RDC 10M689 Vol 3 SYD10/01026/02
MP 10_0065
Pahee Sellathurai
8849 2219

**SYDNEY
REGIONAL
DEVELOPMENT
ADVISORY
COMMITTEE**

KIMBRIKI RESOURCE RECOVERY PROJECT – KIMBRIKI ROAD, TERREY HILLS

Figure 10: Final intersection upgrade works (as agreed to by the RMS and KEE)

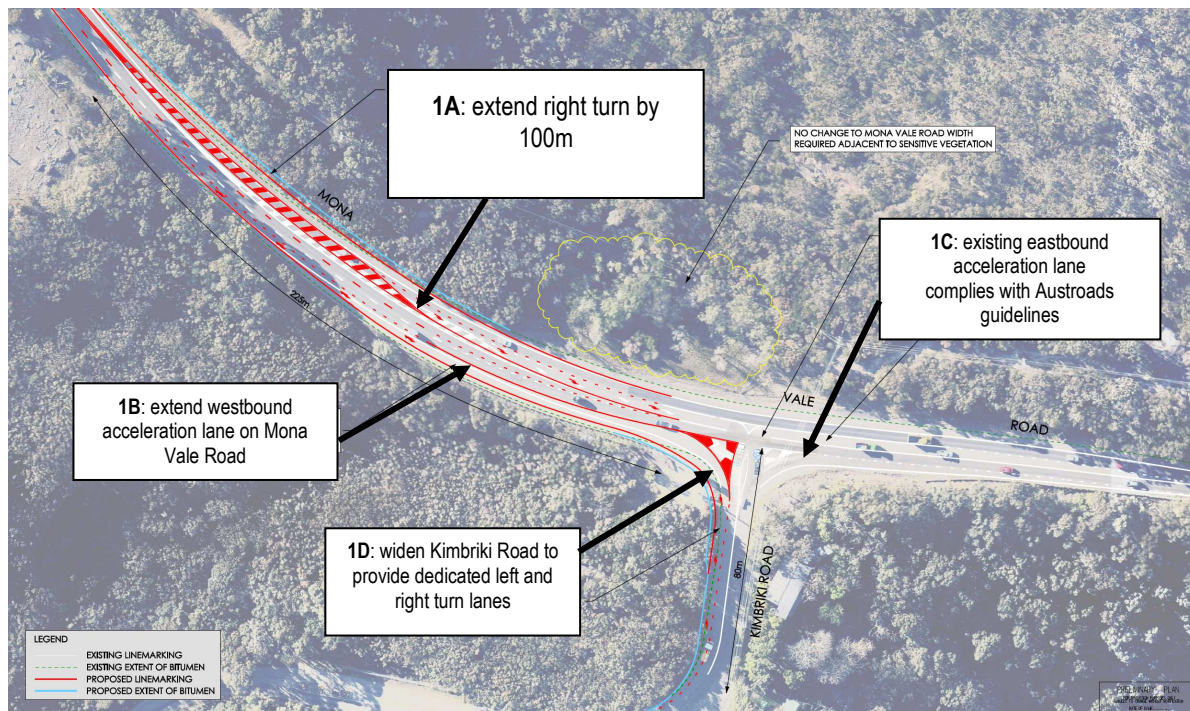
1. To minimise impedance to through movements and to facilitate turning movements into and out of Kimbriki Road, the following improvement works needs to undertaken as part of this development:
 - a. Extend the length of the right turn bay on Mona Vale Road by approximately 30m as suggested in the traffic report;
 - b. Provision of two westbound traffic lanes through the intersection of Mona Vale Road and Kimbriki Road;
 - c. Construction of a westbound acceleration lane on Mona Vale Road; and
 - d. Widening of Kimbriki Road to provide a left turn slip lane and a right turn lane.

The RTA also requires SIDRA modelling, which incorporates the abovementioned improvements, to be undertaken to demonstrate that the intersection of Mona Vale Road and Kimbriki Road will operate satisfactorily.

2. The abovementioned intersection works shall be designed in accordance with RTA Road Design Guide and other Australian Codes of Practice and shall be submitted to the RTA for review and endorsement.
